Your Ref
AL/51/17/PL
Our Ref
PLAN-018393
Date
15/06/2017

Proposal: 1 No. dwelling.

Site: Woodgate Farm, Westergate Street, Westergate, Aldingbourne, PO20 3SS.

AL/51/17/PL

Client	Bryan Fry
Drawing Title	Surface Water Drainage

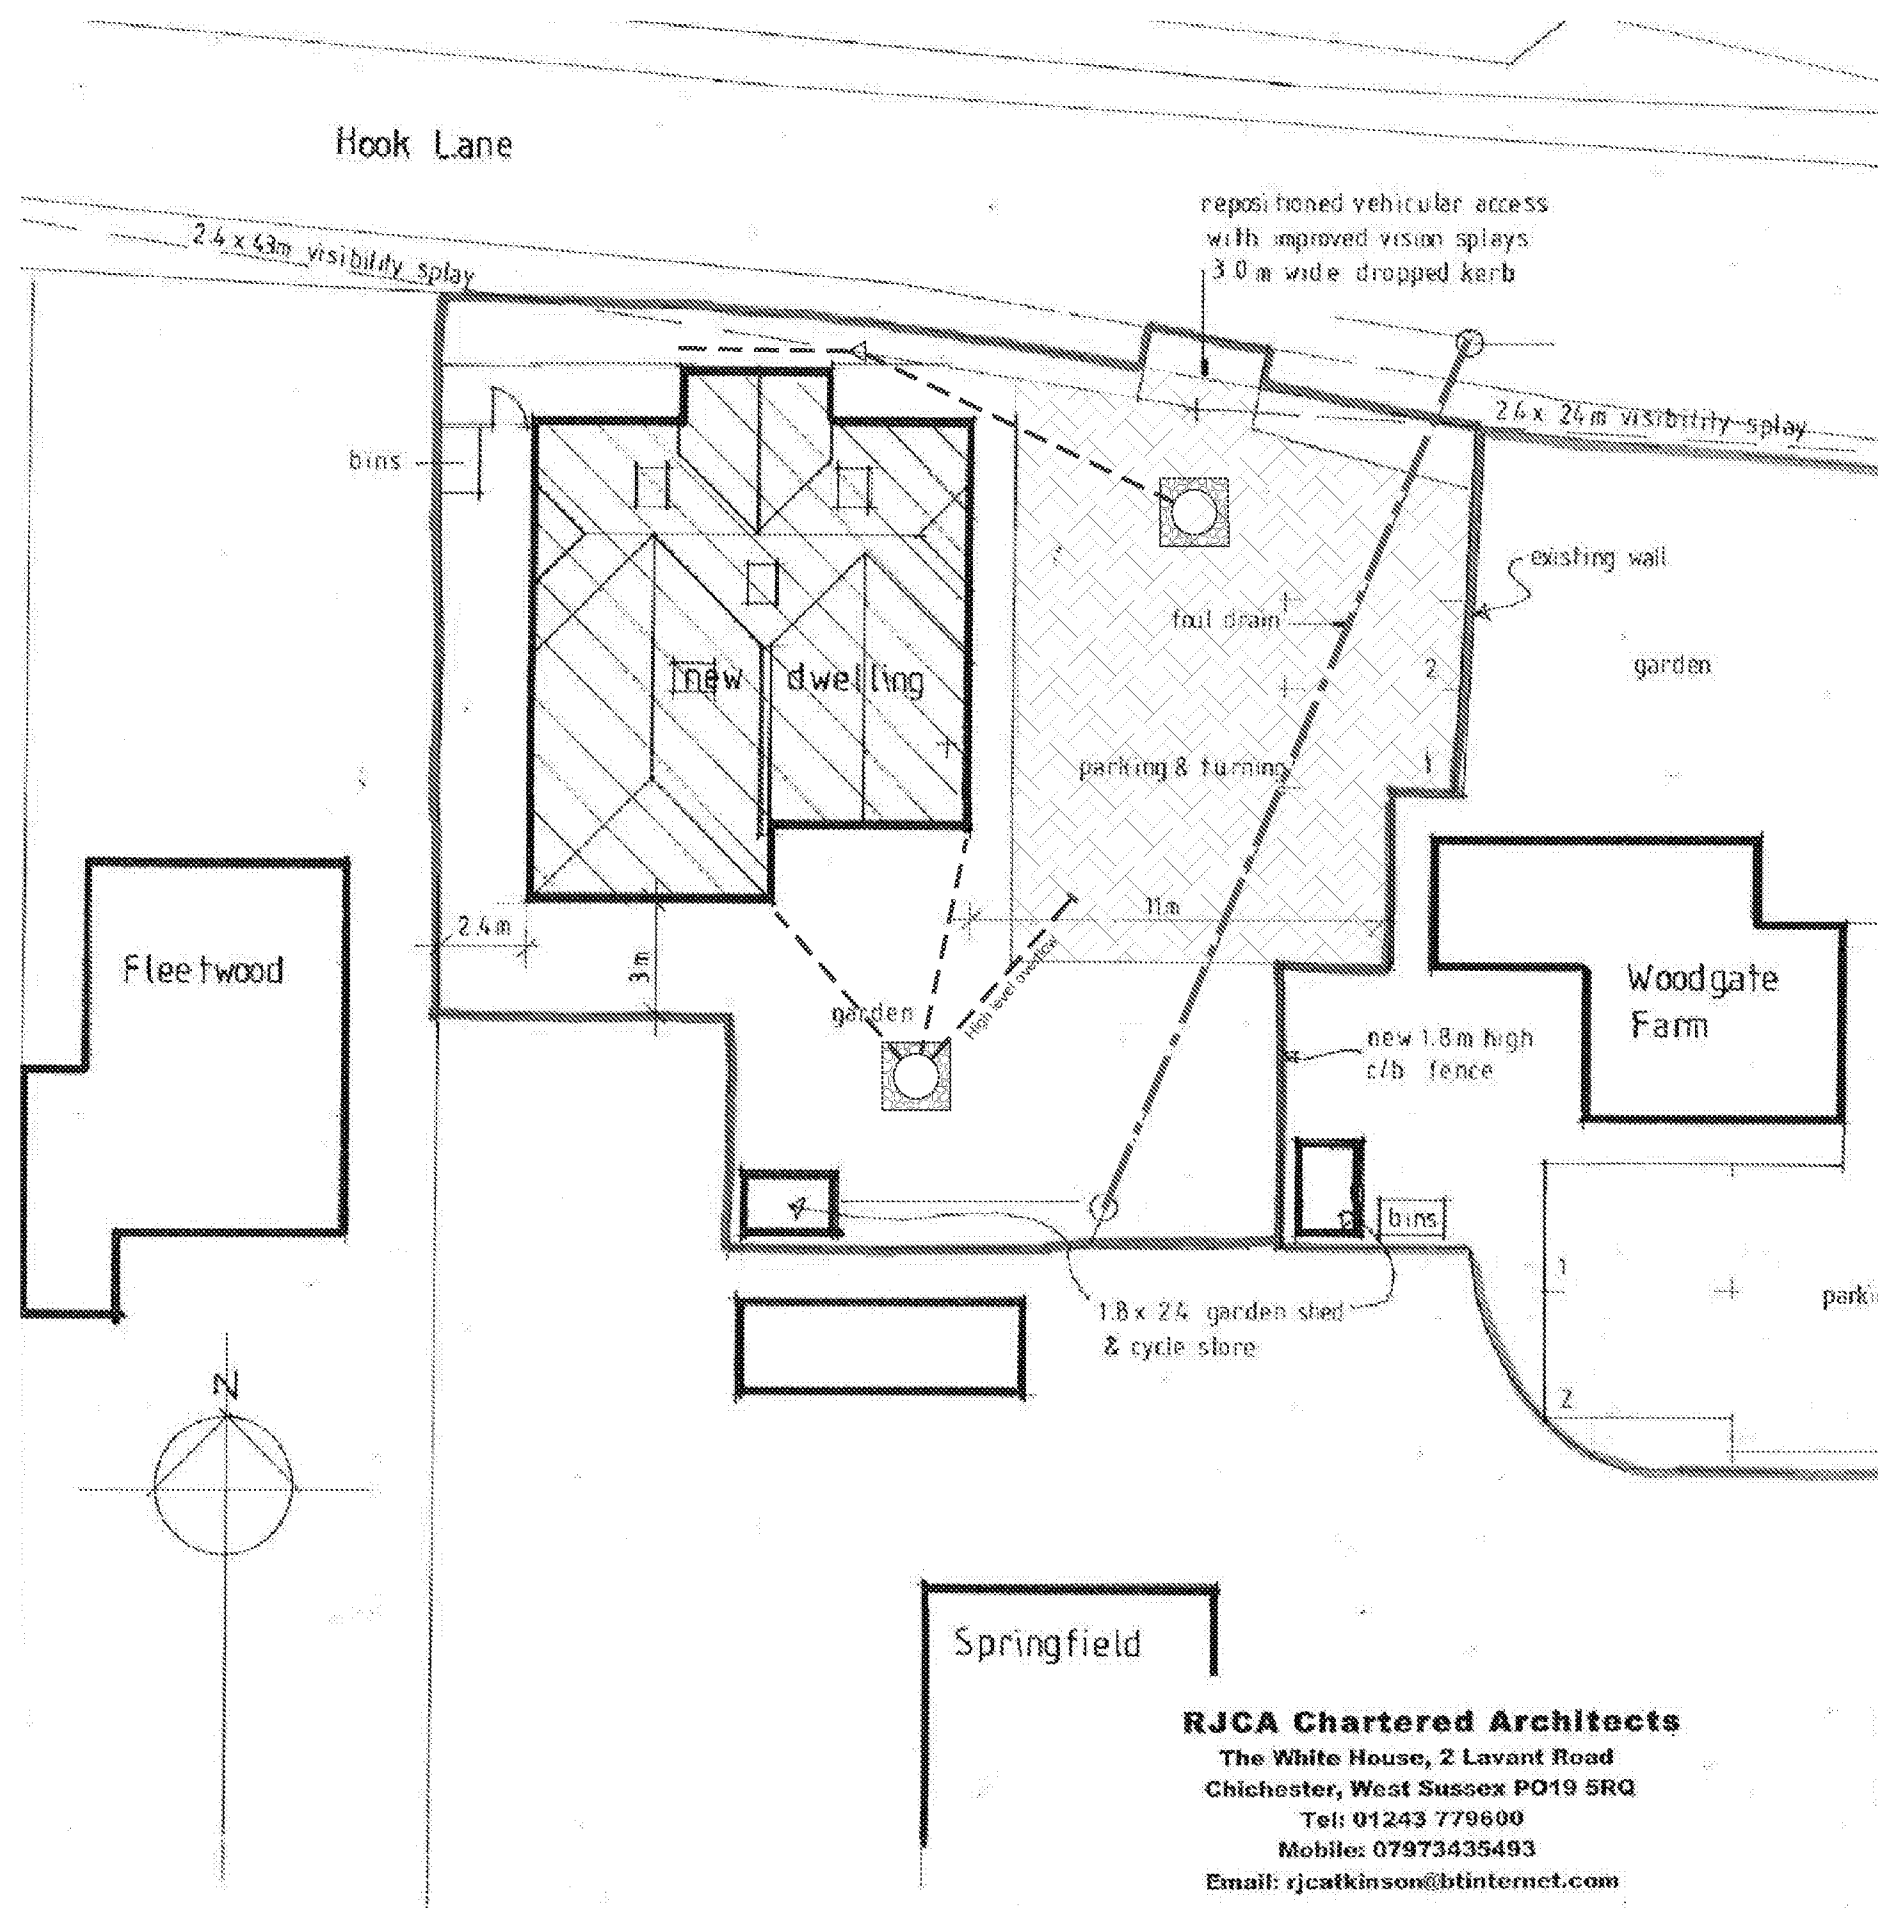
- ***No development or new tree planting should be located within 3 metres either side of the centreline of the public sewer*** and all existing infrastructure should be protected during the course of construction works.
- ***No new soakaways, swales, ponds, watercourses or any other surface water retaining or conveying features should be located within 5 metres of a public sewer, rising main or water main.***

The construction of permeable paving over public sewers will not be acceptable. The design of drainage should ensure that no land drainage or groundwater is to enter public sewers network.

The Council's Building Control officers or technical staff should be asked to comment on the adequacy of soakaways to dispose of surface water from the proposed development.

The planning application form makes reference to drainage using Sustainable Urban Drainage Systems (SUDS).

Under current legislation and guidance SUDS rely upon facilities which are not adoptable by sewerage undertakers. Therefore, the applicant will need to ensure that arrangements exist for the long term maintenance of the SUDS facilities. It is critical that the effectiveness of these systems is maintained in perpetuity. Good management will avoid flooding from the proposed surface water system, which may result in the inundation of the foul sewerage system. Thus, where a SUDS scheme is to be implemented, the drainage details submitted to the Local Planning Authority should:

- Specify the responsibilities of each party for the implementation of the SUDS scheme
- Specify a timetable for implementation
- Provide a management and maintenance plan for the lifetime of the development.
